Re: Revisions to Planning Application for 68 The Drive Bognor Regis PO21 4DS

Please find enclosed 4 complete sets of the following revised plans:

Drq No.	Rev
68/2014/60P	A

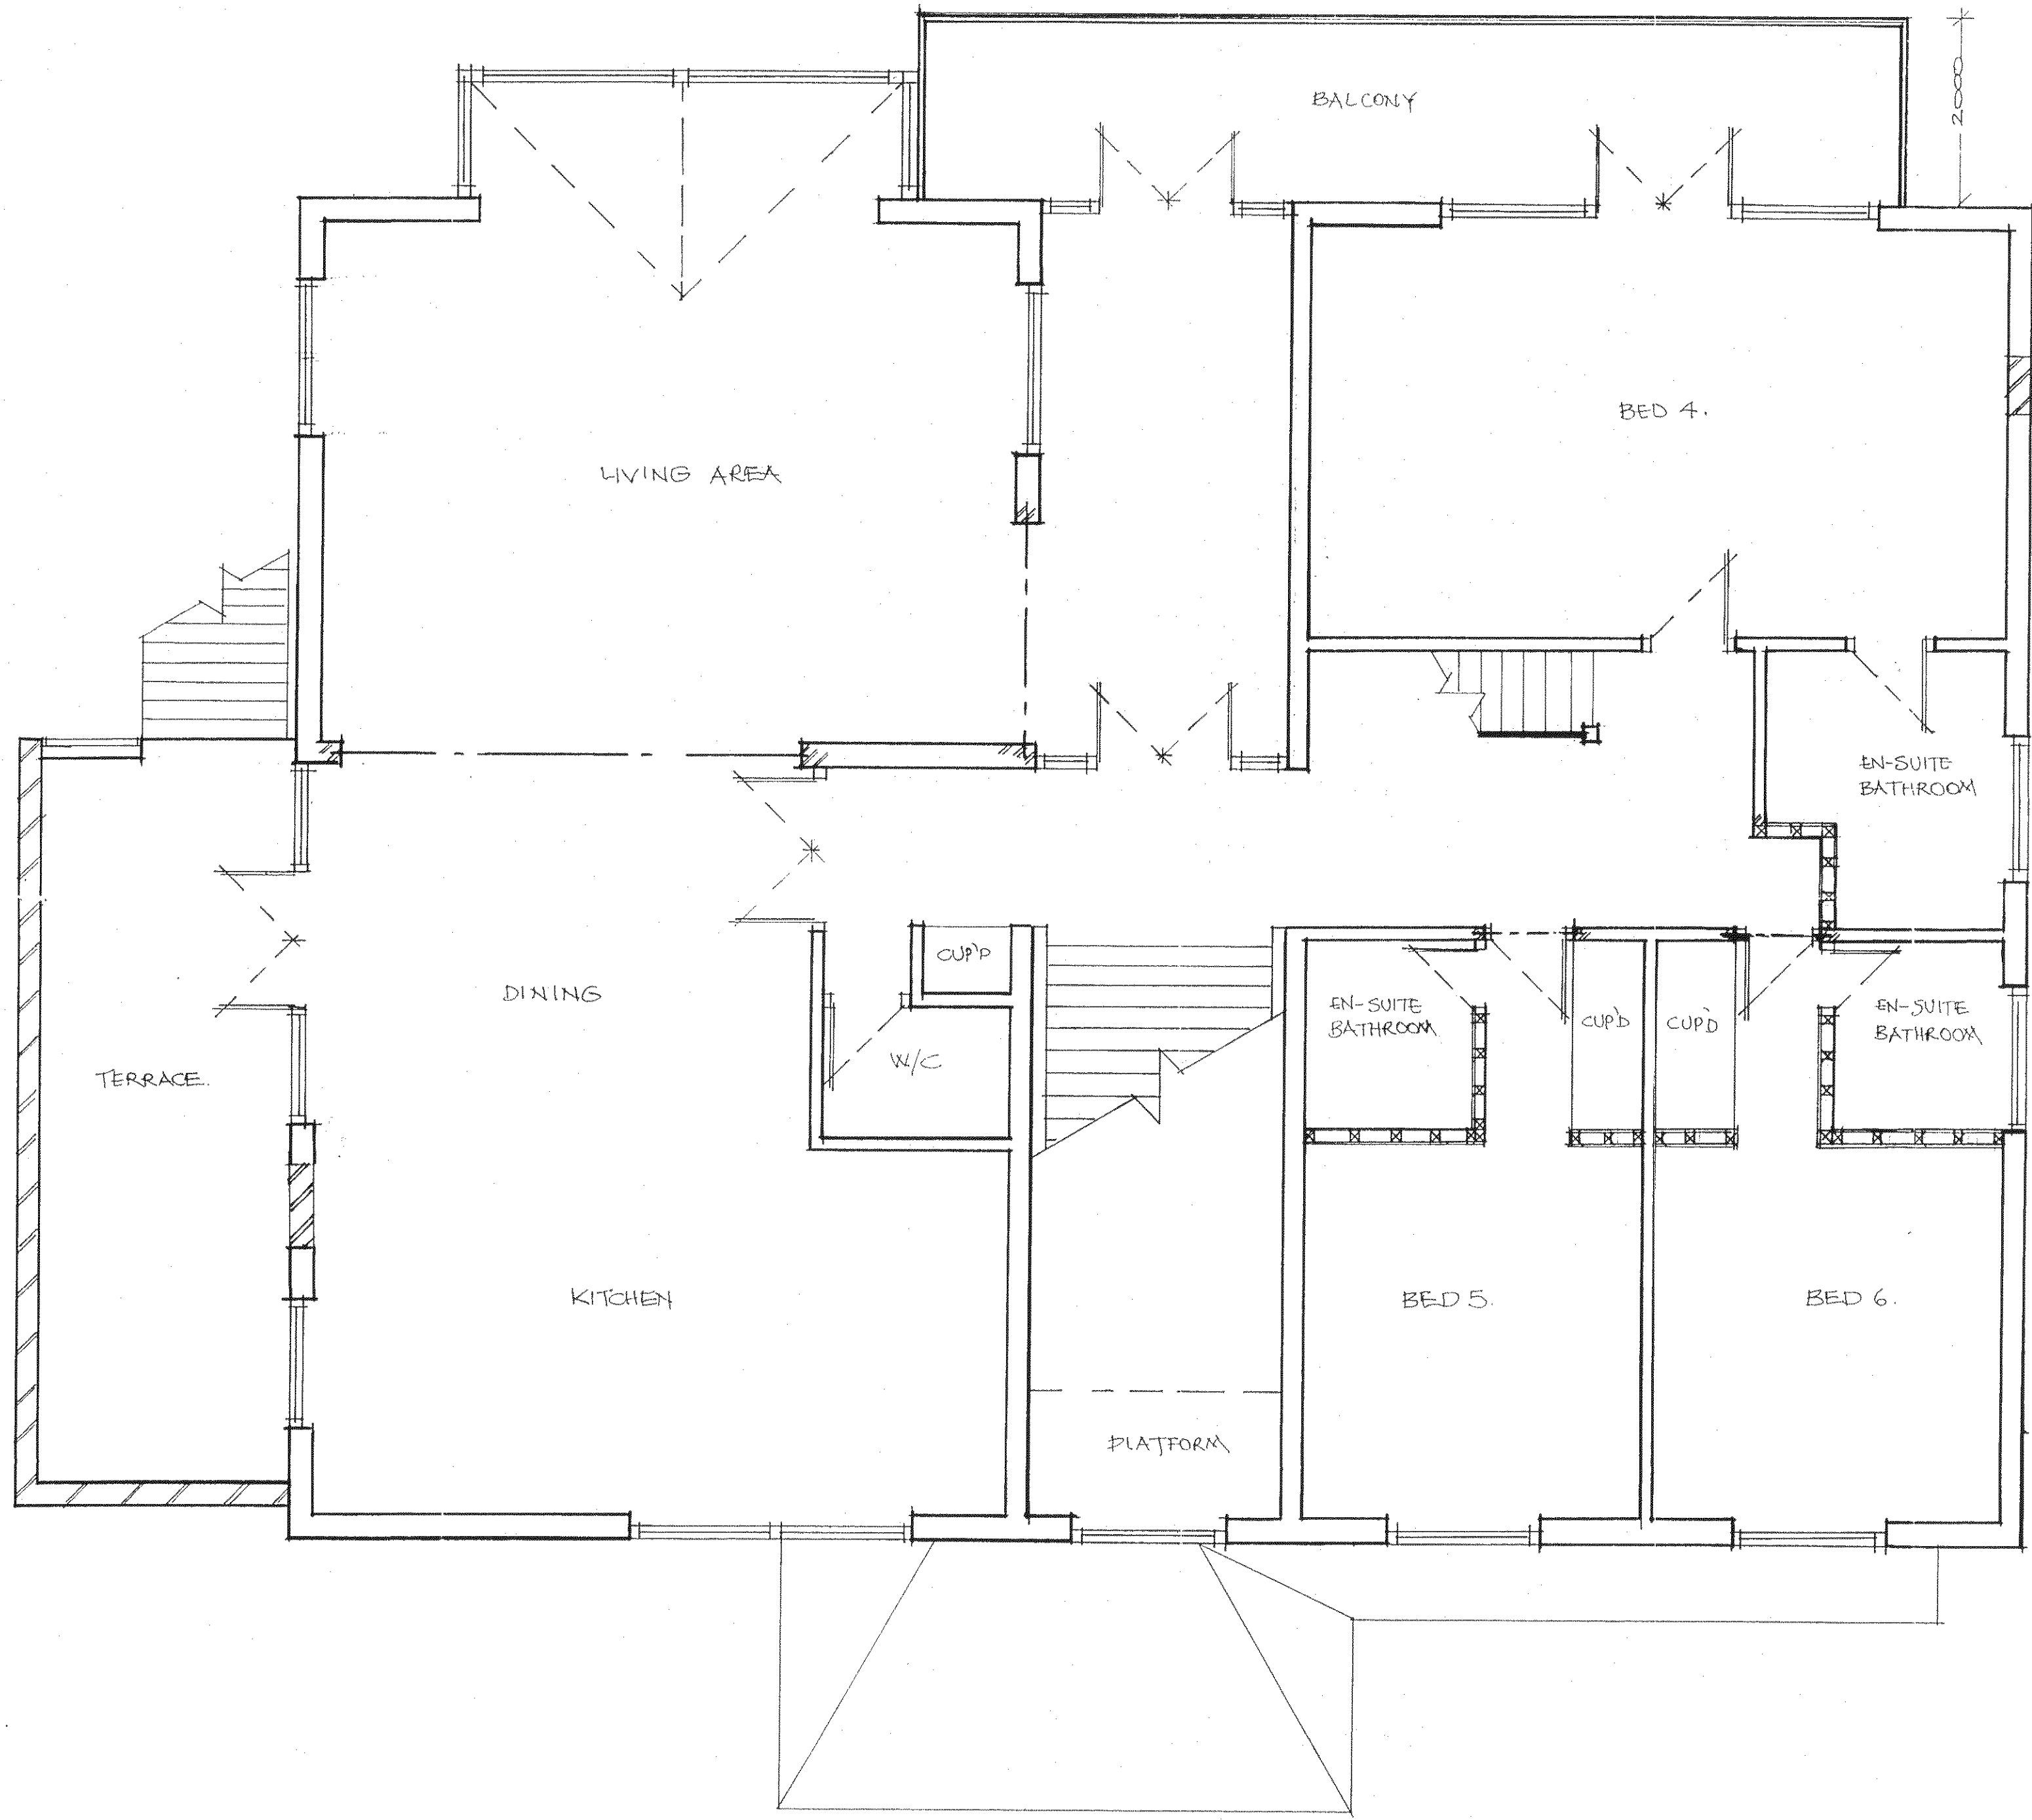
Dwg 68/2014/60P - Removal of the original external door to the East Elevation which now corresponds with the proposed elevation **Dwg 68/2014/30P Rev B**.
